From: [REDACTED]
To: [REDACTED]
Cc: [REDACTED]
Subject: RE: 23/1195/LB Tower Farmhouse, Station Road, Tower End, Middleton, Norfolk
Date: 18 August 2023 08:30:10
Attachments: [image003.png](#)
[image004.png](#)
[image005.png](#)
[image006.png](#)

Thank you for informing the Georgian Group of an application to undertake works of demolition and alteration to the above grade II listed building. The Group wishes to register its formal objection to these proposals for the following reasons.

project:	Proposed Extension & Alterations Tower Farm Middleton Norfolk	sheet size:	A1
date:	March 2023	scales:	As Shown
revision:	E	ref:	669 - 04

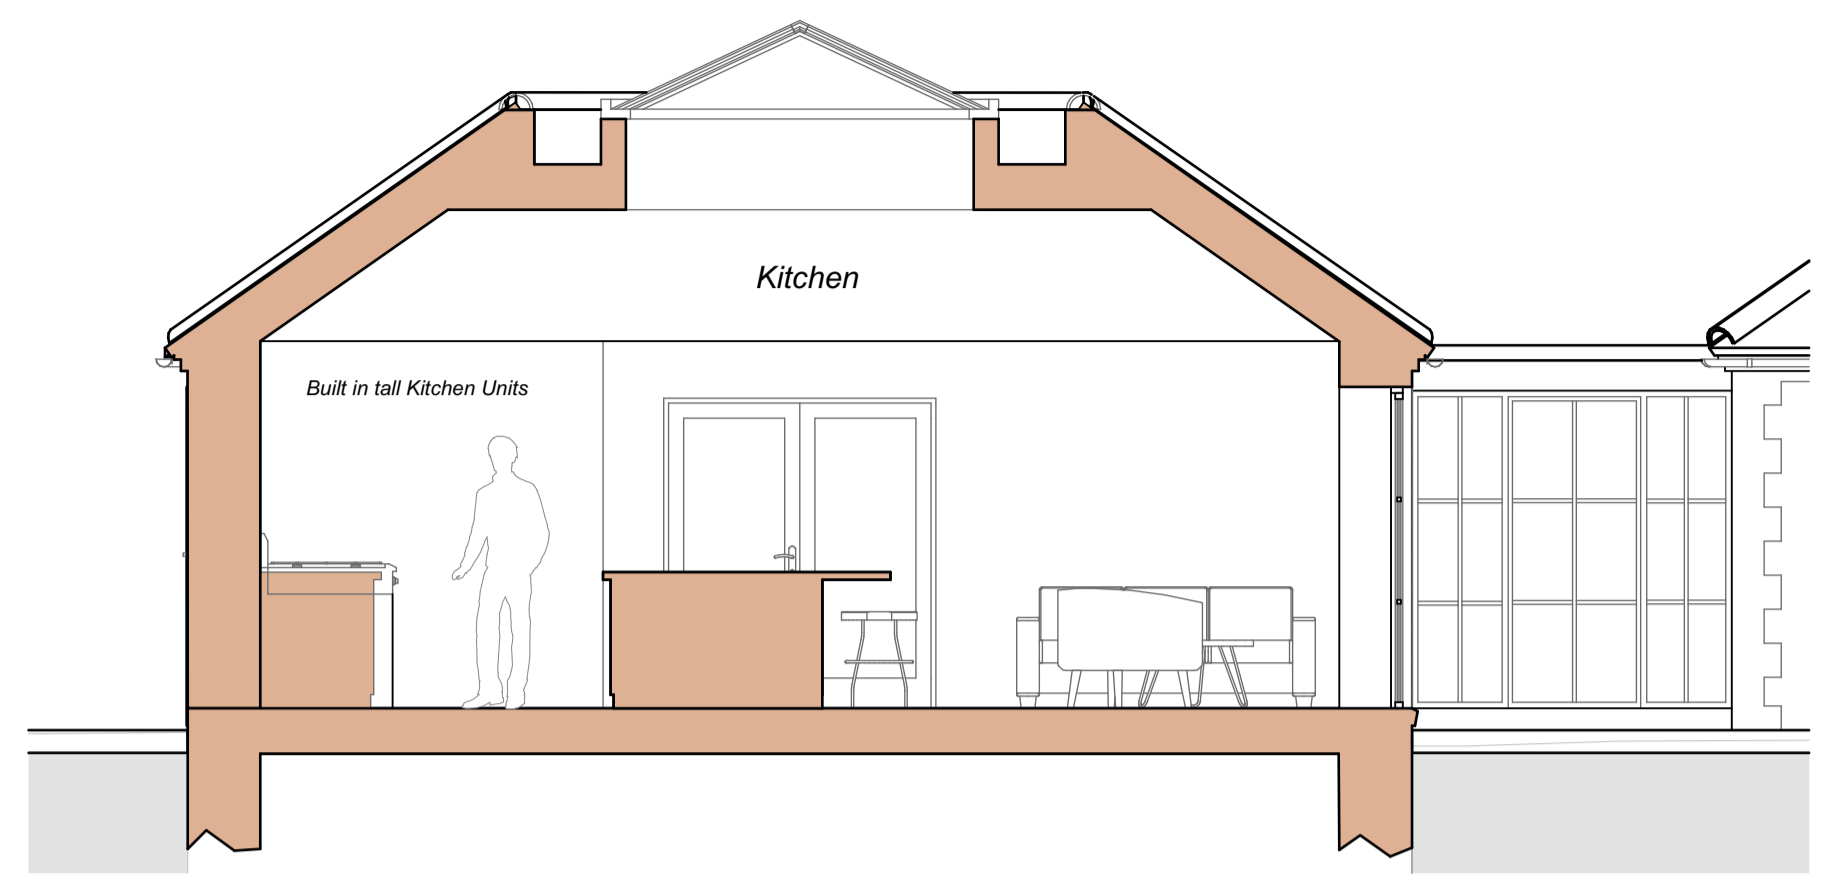
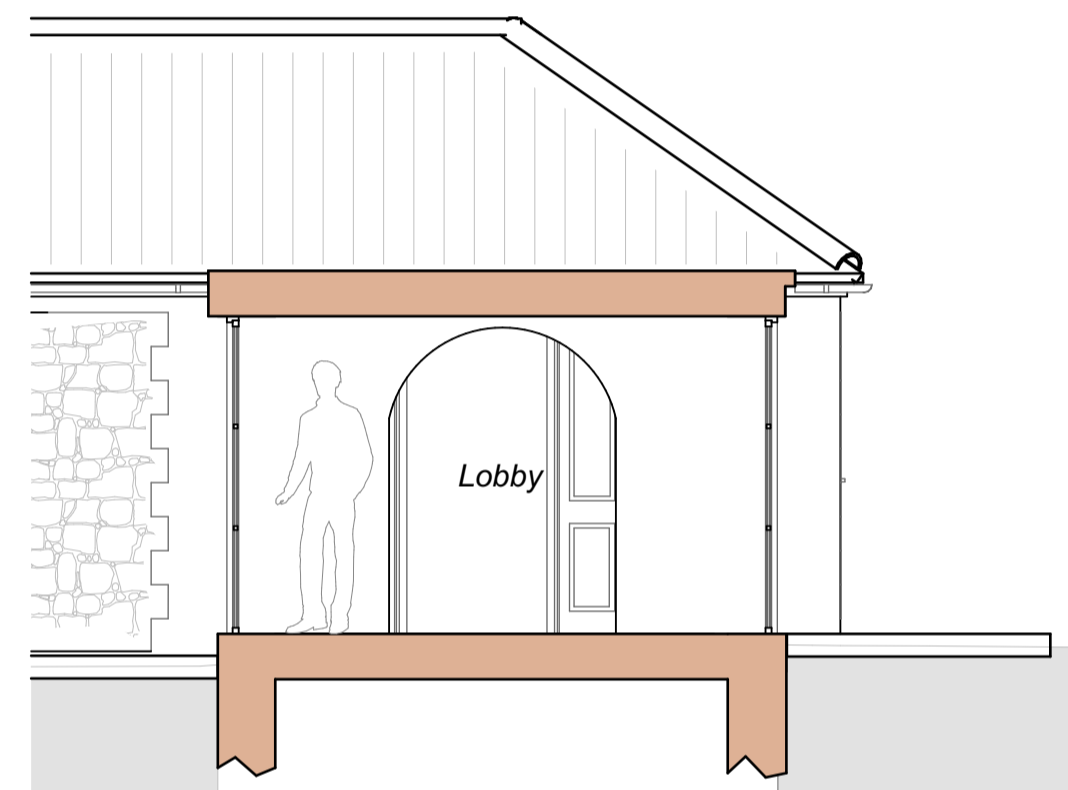
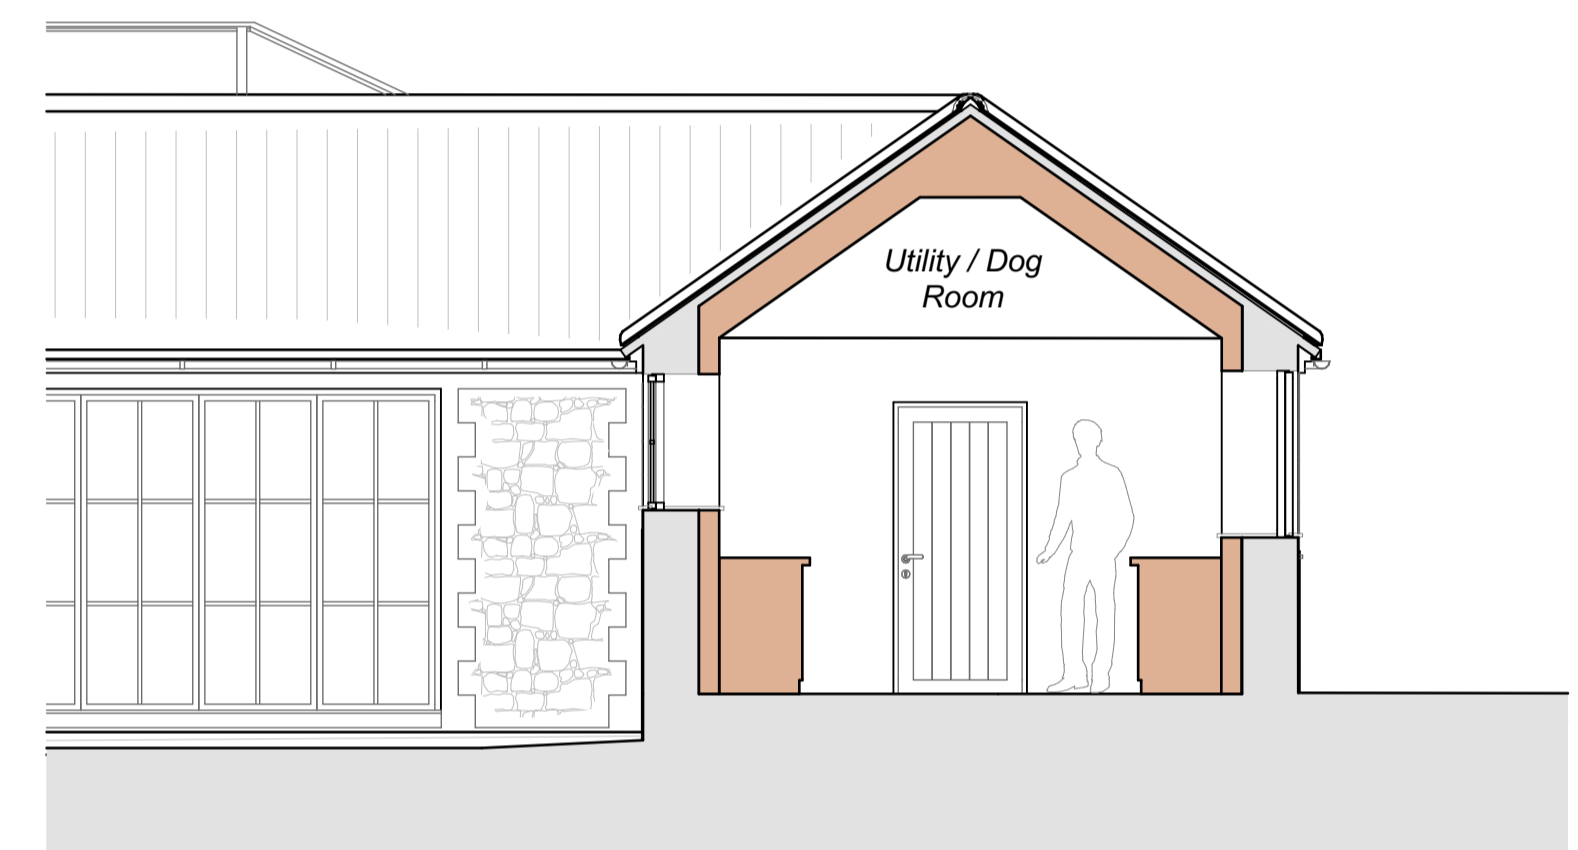
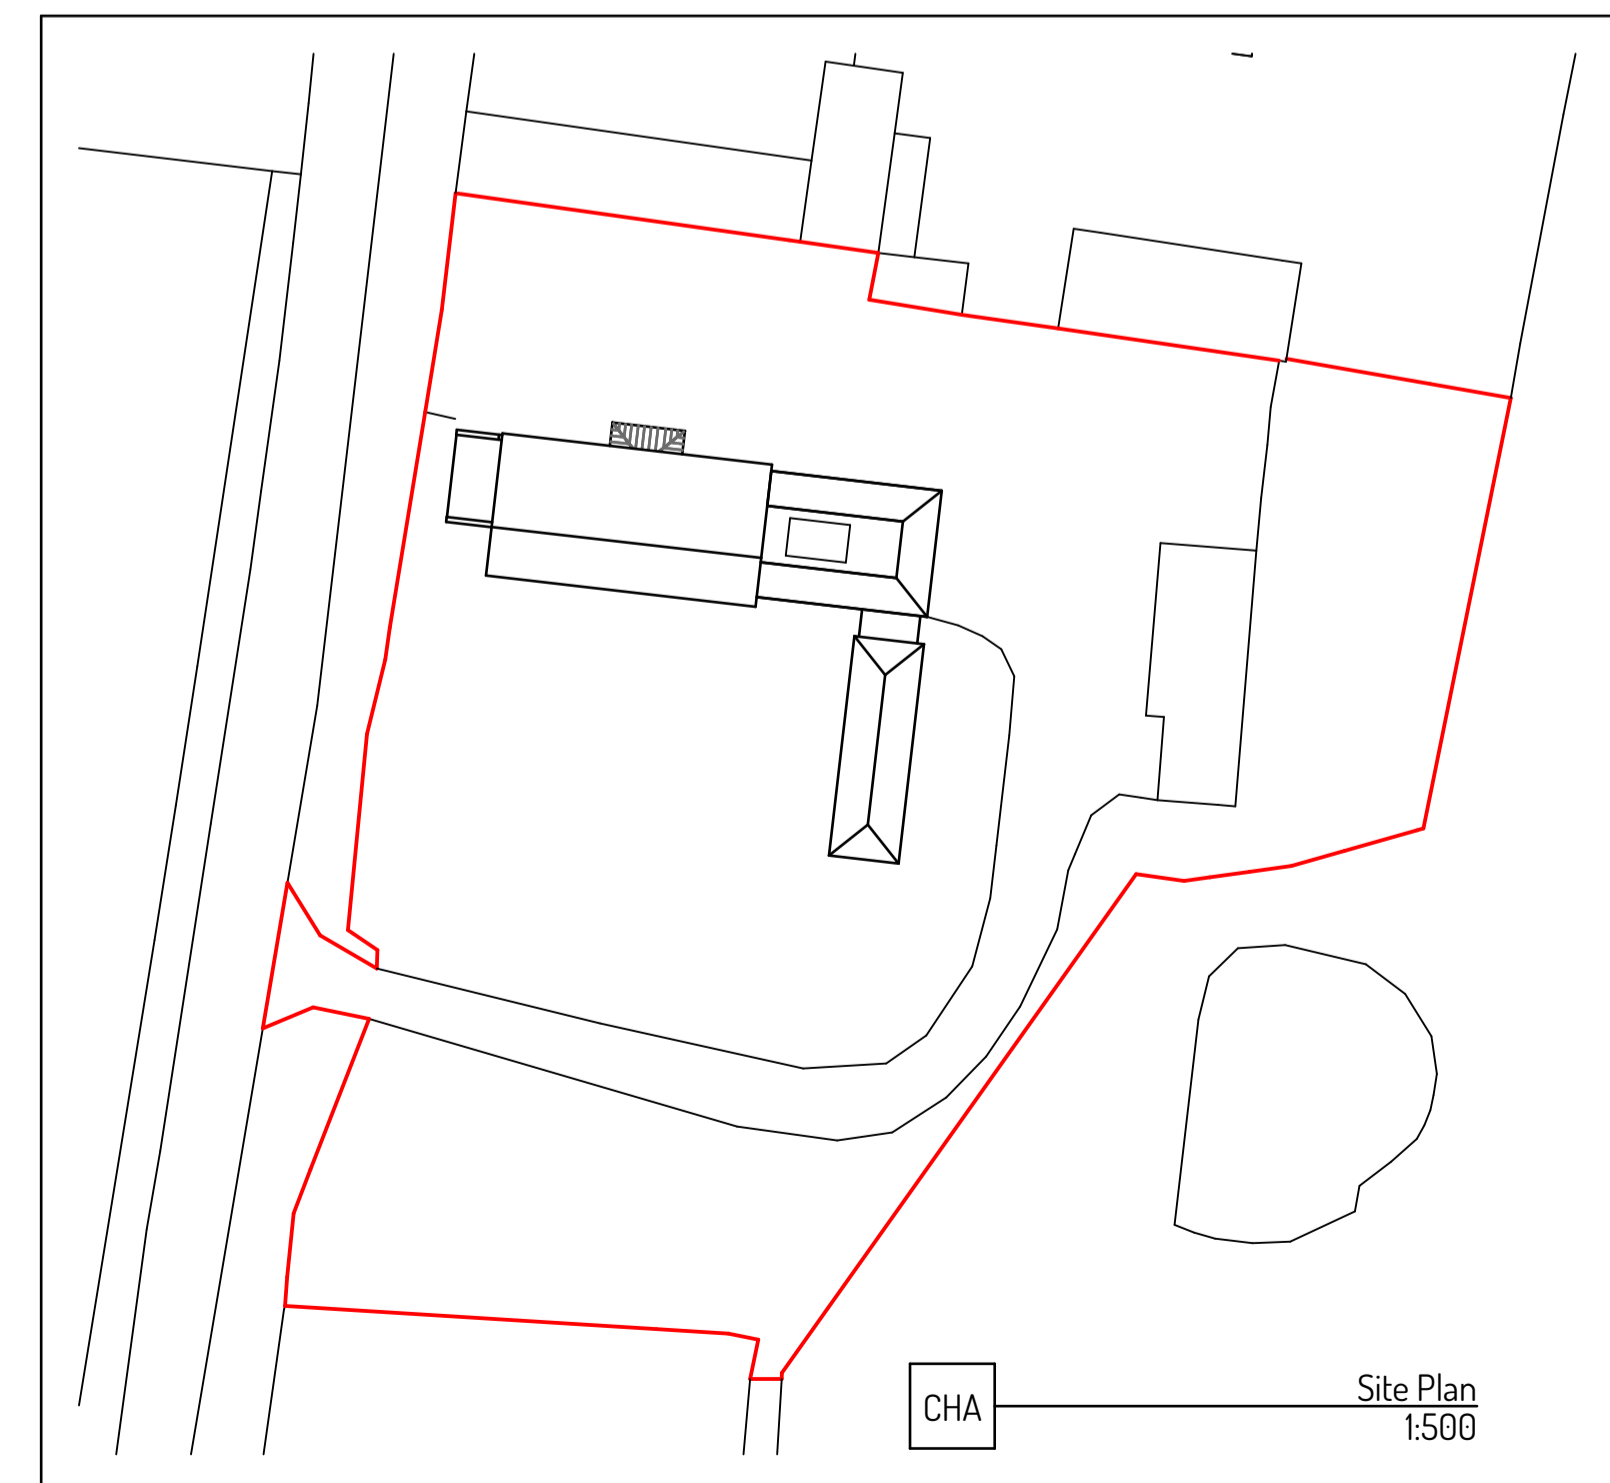
The Group has concerns about the size of the proposed replacement structure in relation to the existing farmhouse, and about its relationship to the adjacent outbuilding. Extending the new wing to the north will also lead to the loss of an historic window opening within the gable. The proposed roof lantern is a particularly assertive element of the proposed design which will detract from the setting of the original listed building.
